233 Woodside Drive, Great Diamond Island - City Comment Response

City Comments:

## SITE & GRADING PLAN

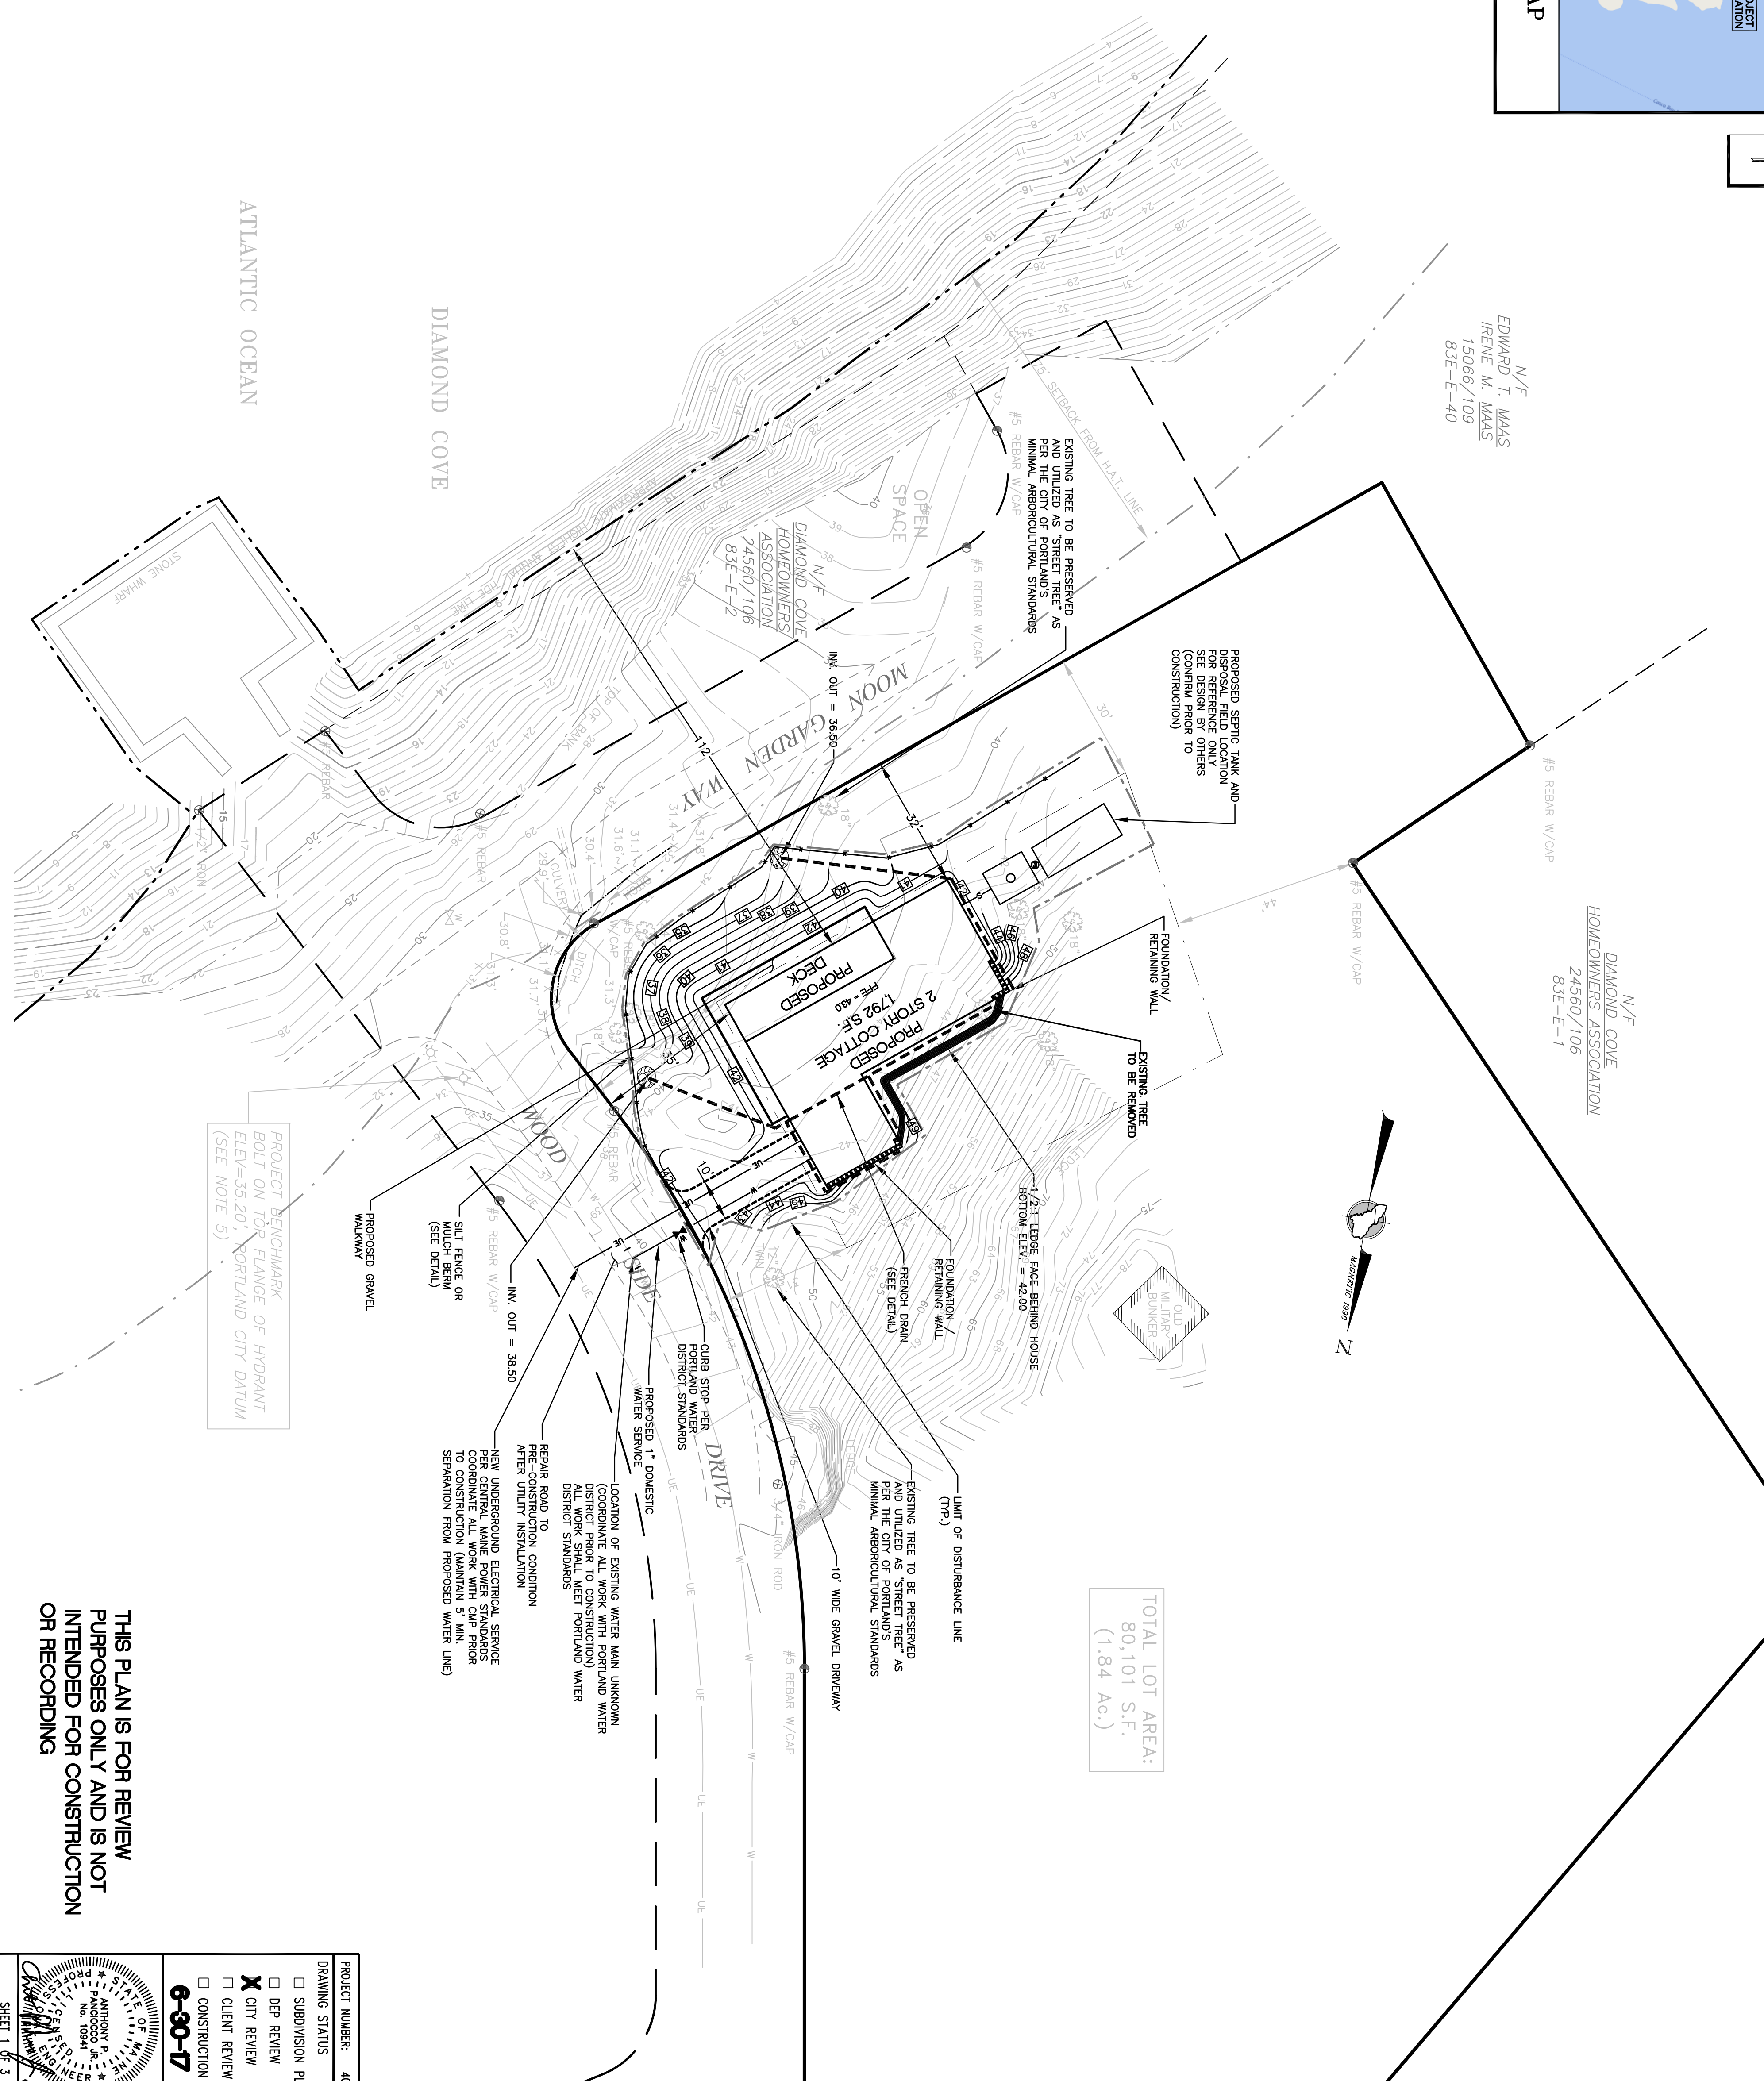
4(A)- The "wrap around" structure is a walkway around the front and side of the deck (please see call out on revised site plan)

4(C)- The previously submitted site plan shows the HAT line and a distance from the HAT line to the proposed dwelling. The revised plan shows the 75' setback line in relation to the structure.

6- A note has been added to the site plan stating that all standards of 14-449(c) will be met. The parcel, as shown on the revised plan, is completely outside the 75' setback, therefore there will be no cutting within 75' of the HAT line. Minimal vegetation removal will result as part of this project. The revised plan calls out the only tree to be removed due to development. The proposed dwelling is located in a cleared area of the parcel as shown on the site plan survey and will result in minimal cutting.

7- The amended plat was not required as part of this submission. Barbara Barhydt stated specifically, which we have in writing, that the entire subdivision plat does not have to be re-created in order to show a change to the building envelope for one lot. All significant vegetation on the "water side" of the property and in the area of development is located on the site plan.
